CITY OF ALBUQUERQUE

June 13, 2019

**RE: Alameda Luxury Apartments
8400 Alameda Blvd NE
Conceptual Grading and Drainage Plan
Engineer's Stamp Date: 05/30/19
Hydrology File: C20D057**

Erosion and Sediment Control Plan

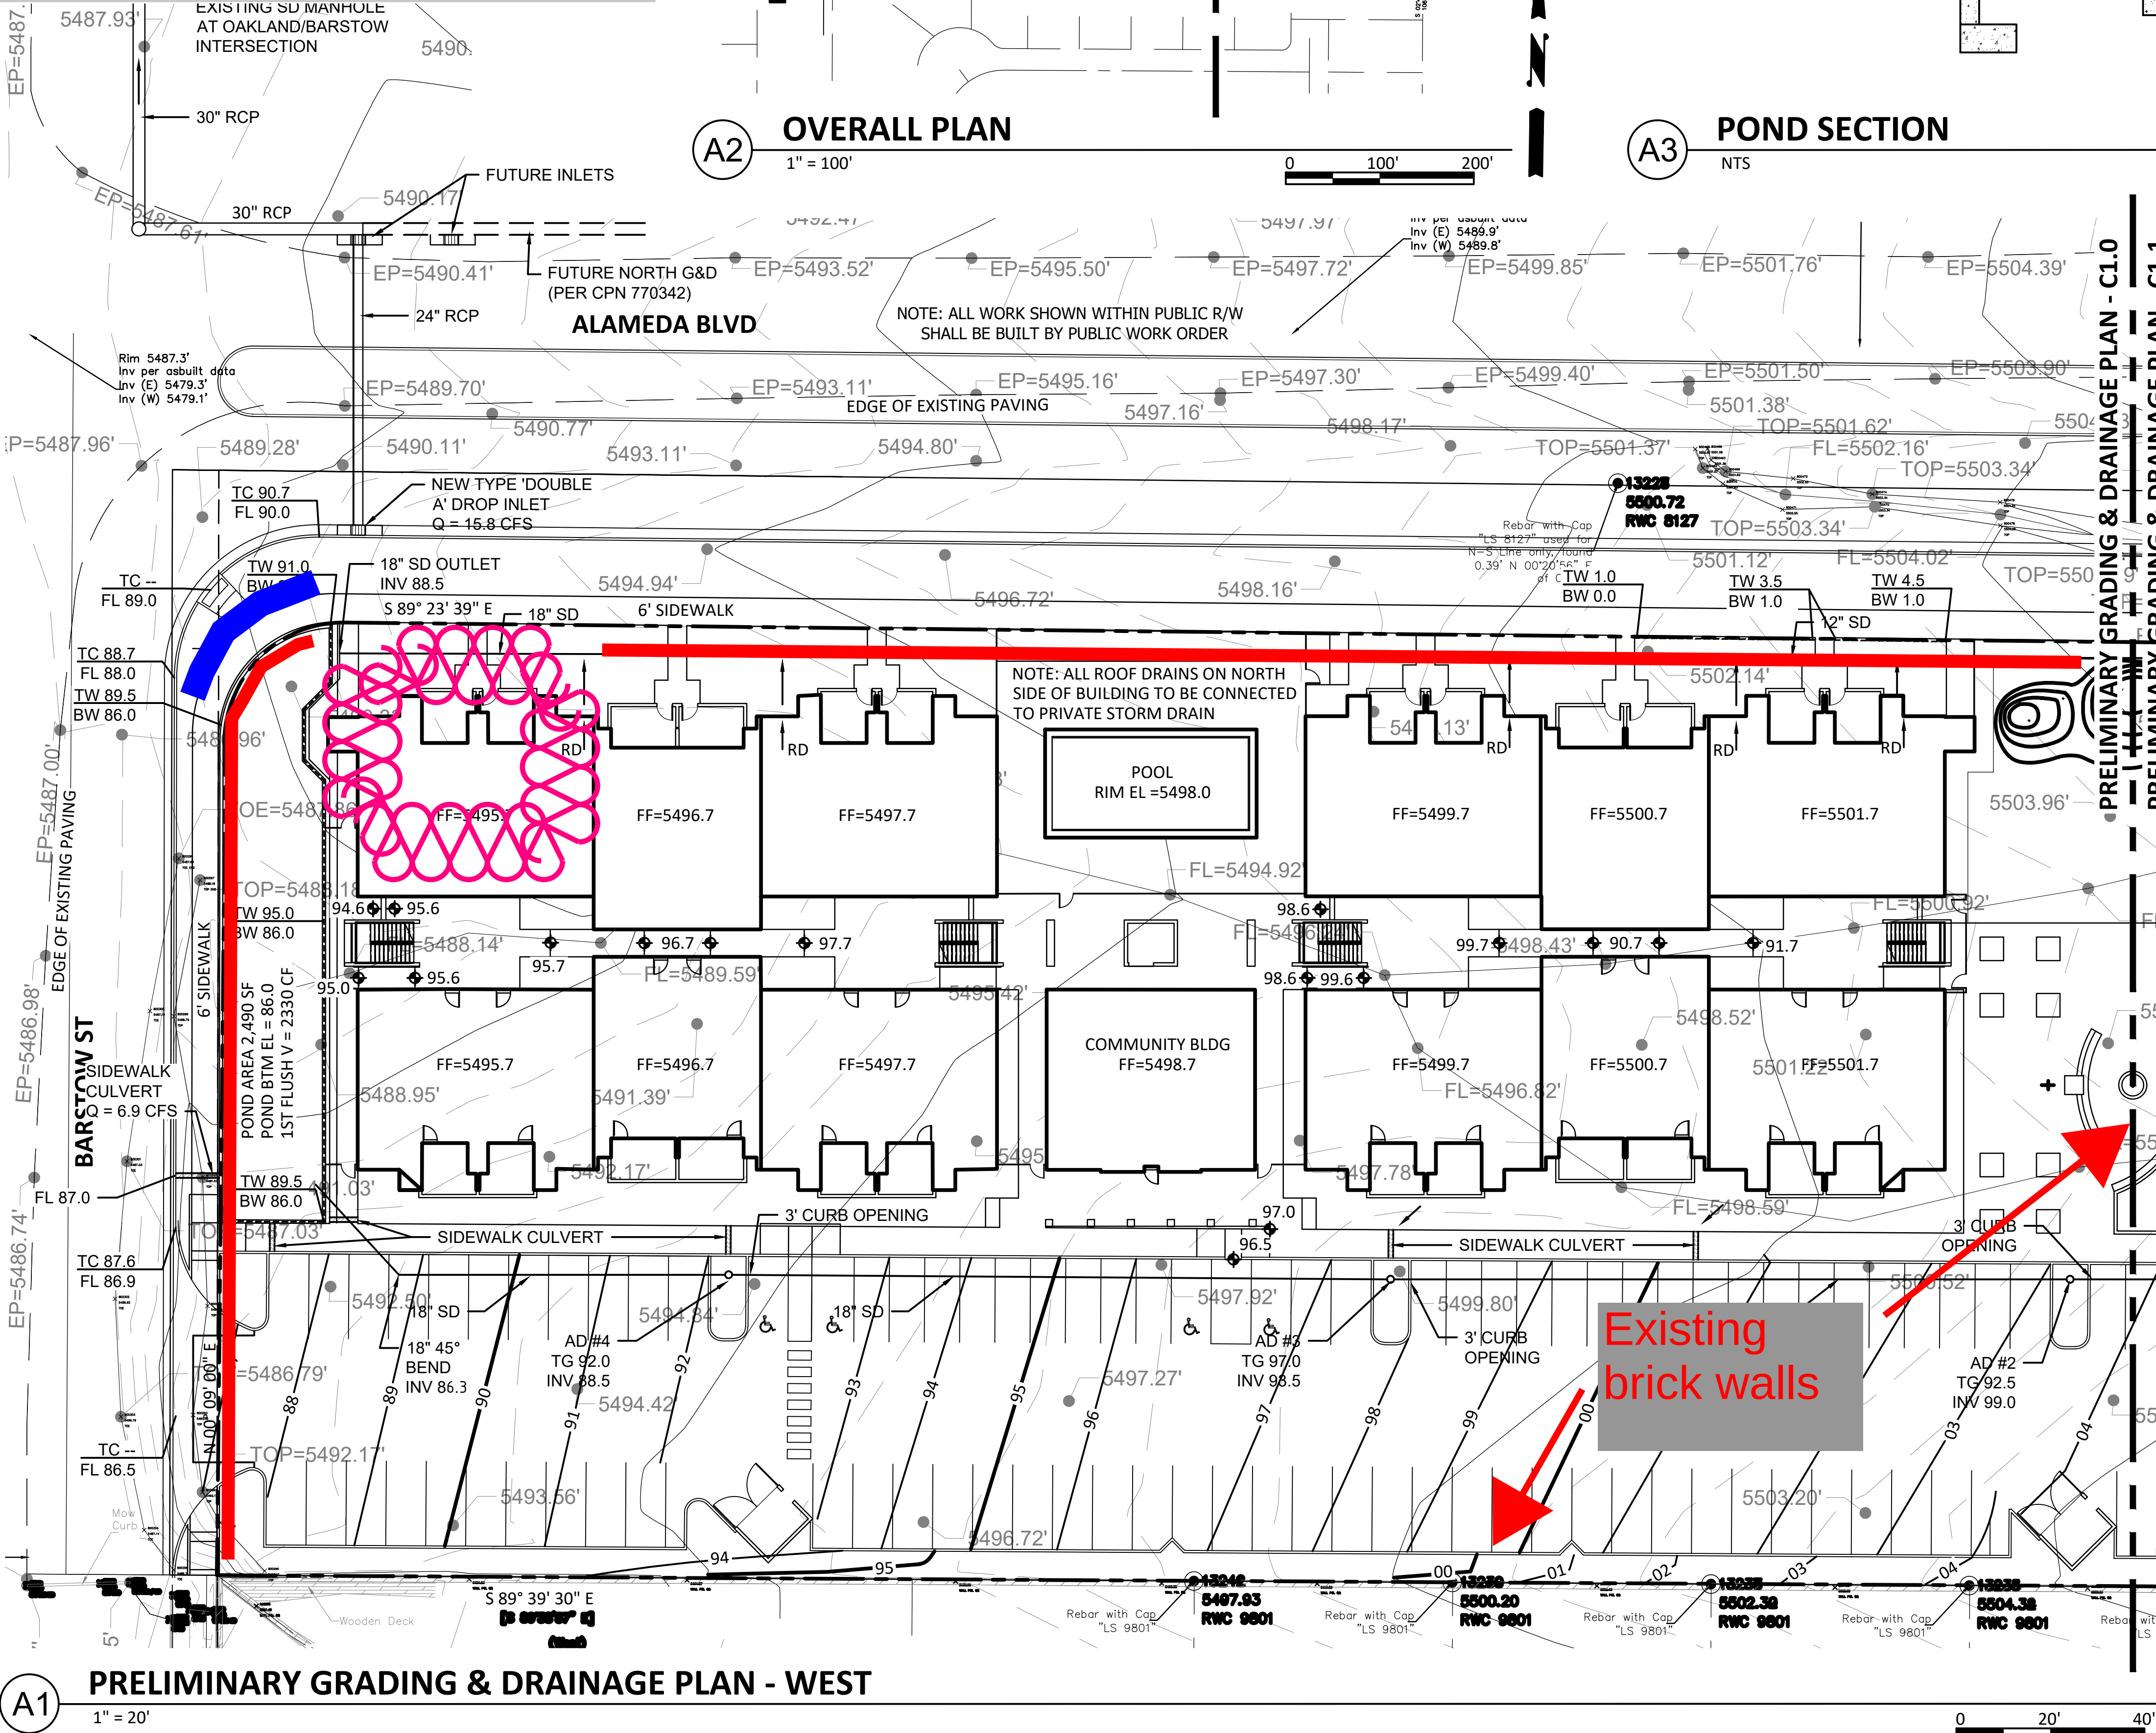
2. Please add a note stating "Not for Construction" on both sheets.
3. Under the Existing Conditions, please add a statement that this site is part of North Albuquerque Acres Master Drainage Plan (NAAMDP) with an allowable discharge rate of 2.38 cfs/ac.

STREET CAPACITY

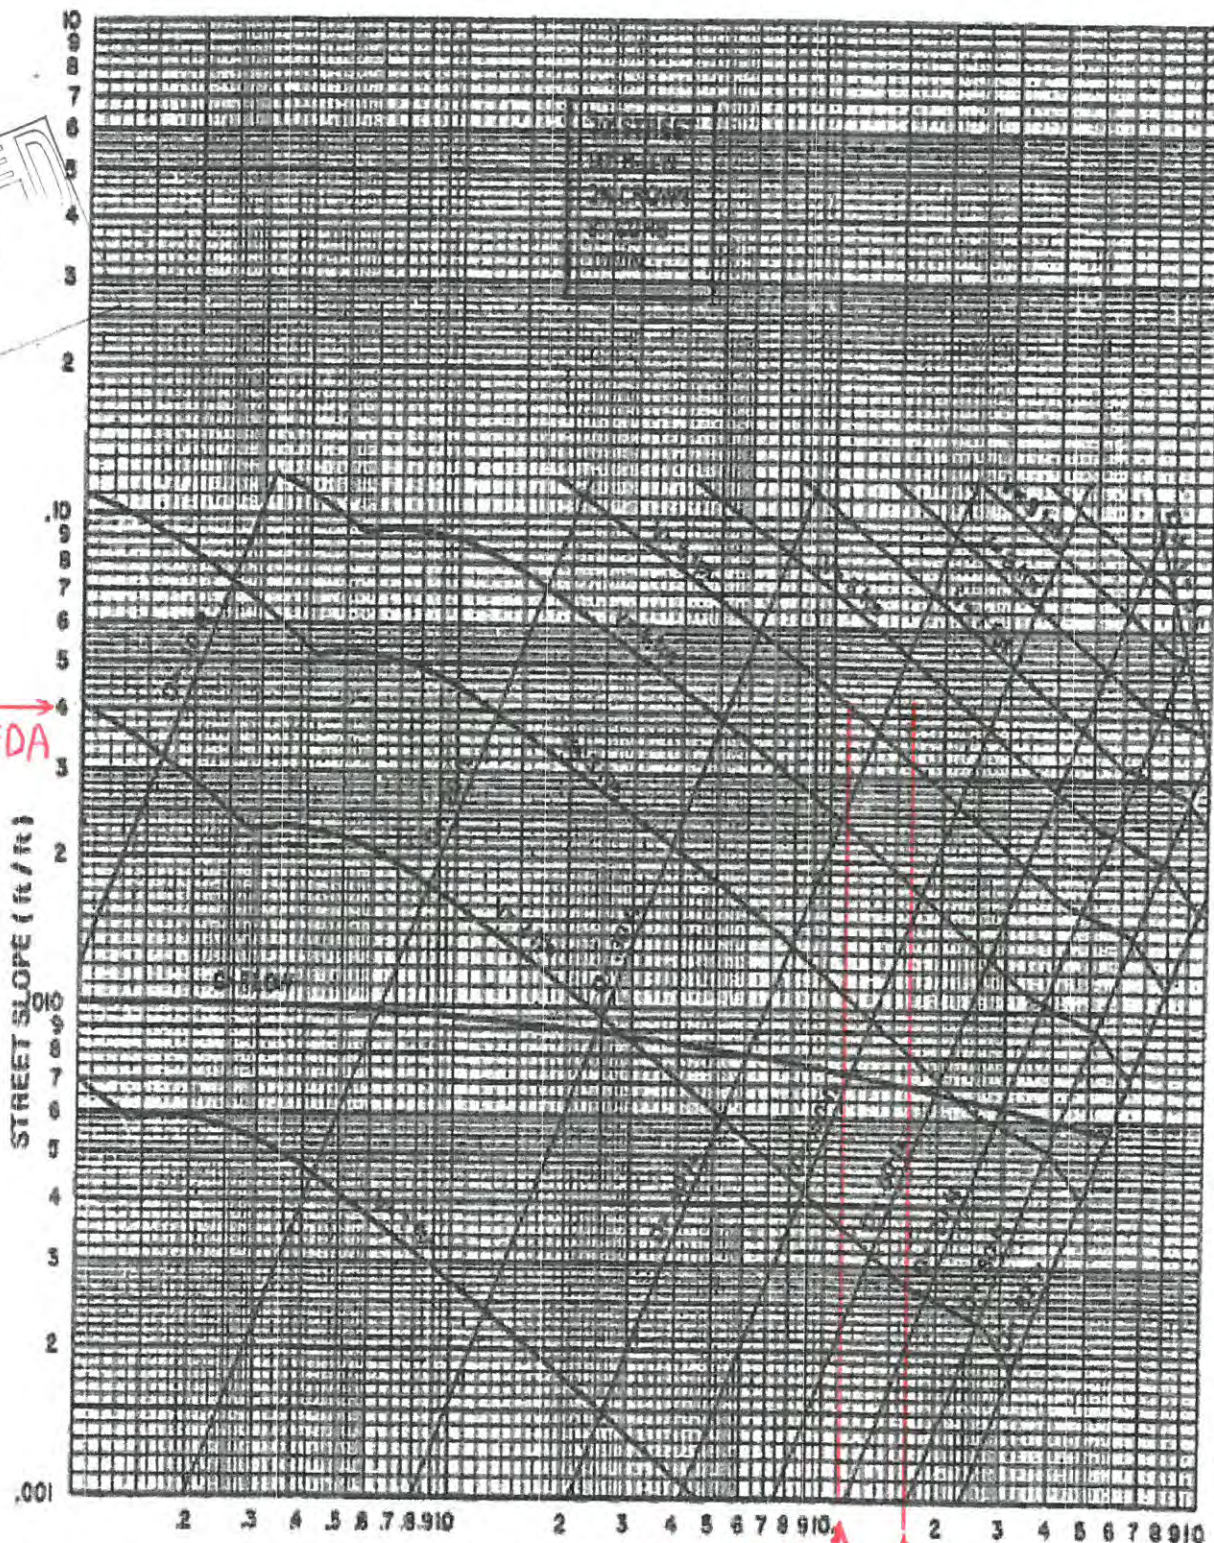
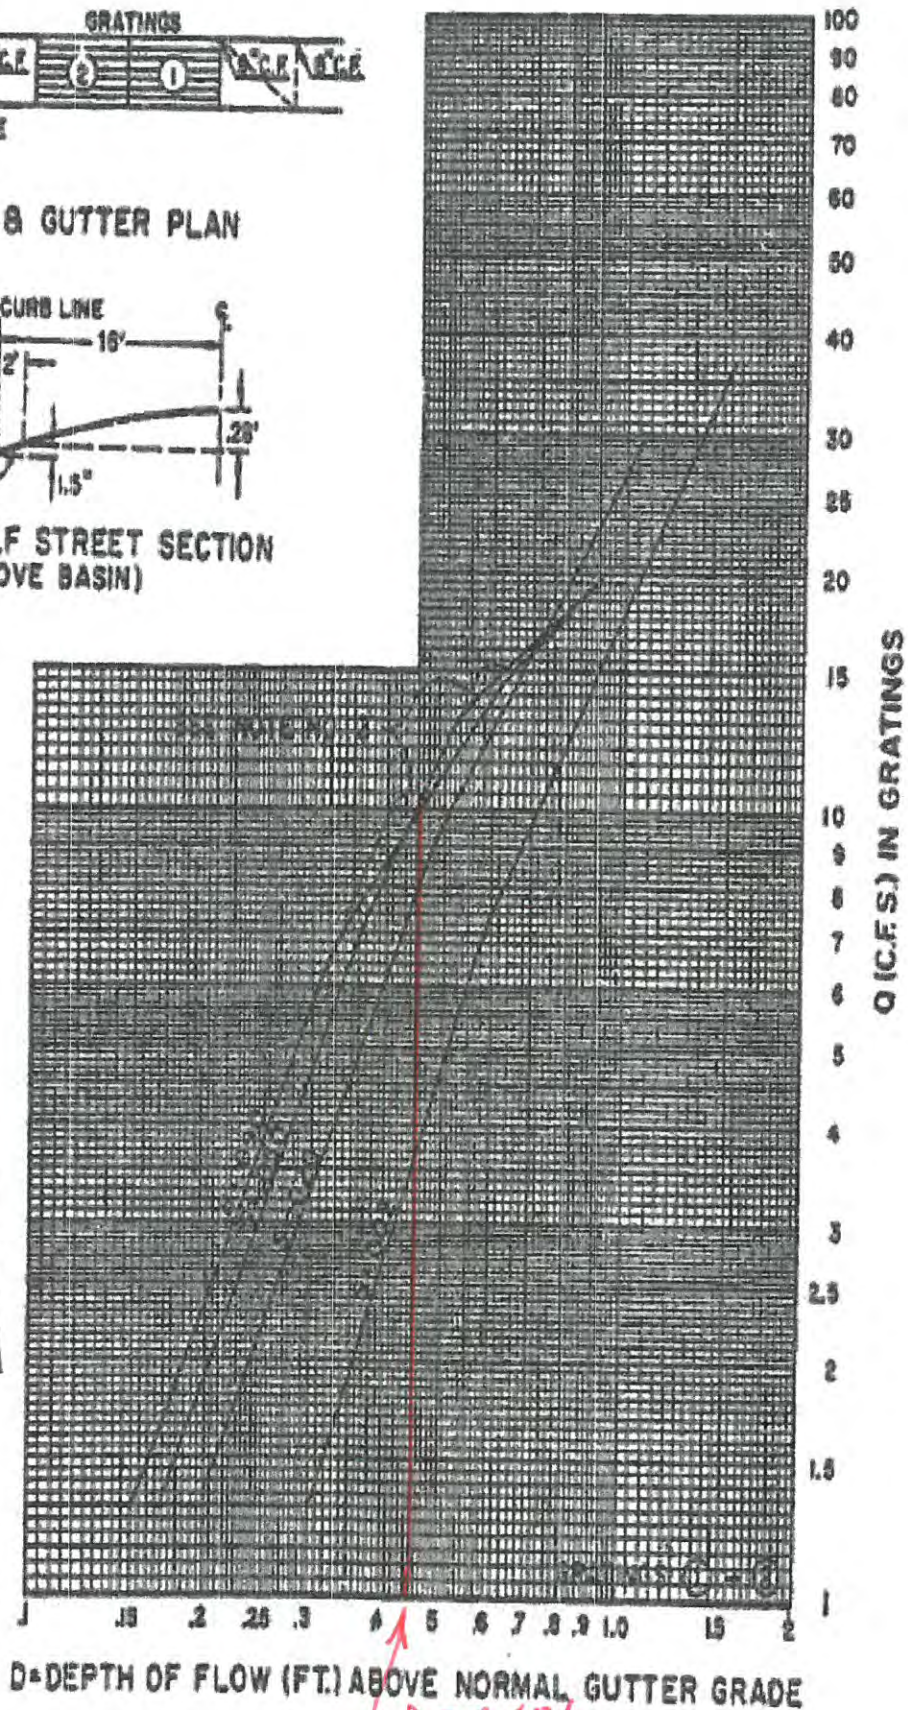
4. Please provide a typical section of the detention pond along Barstow. Also the footer for the retaining wall must be within the property.
5. Please provide the capacity calculations for South lanes of Alameda Blvd. The drainage areas should also include the east adjacent development which discharges into Alameda. Per Chapter 22 Section 3.E (Street Hydraulics) of the DPM, the calculations are for the 10 year and 100 year storm event.

6. Per NAAMDP and the calculations from comment #5, a storm drain inlet should be required on Alameda just before Barstow. This inlet must drain to the north on Barstow to an existing storm manhole at the intersection of Oakland & Barstow.
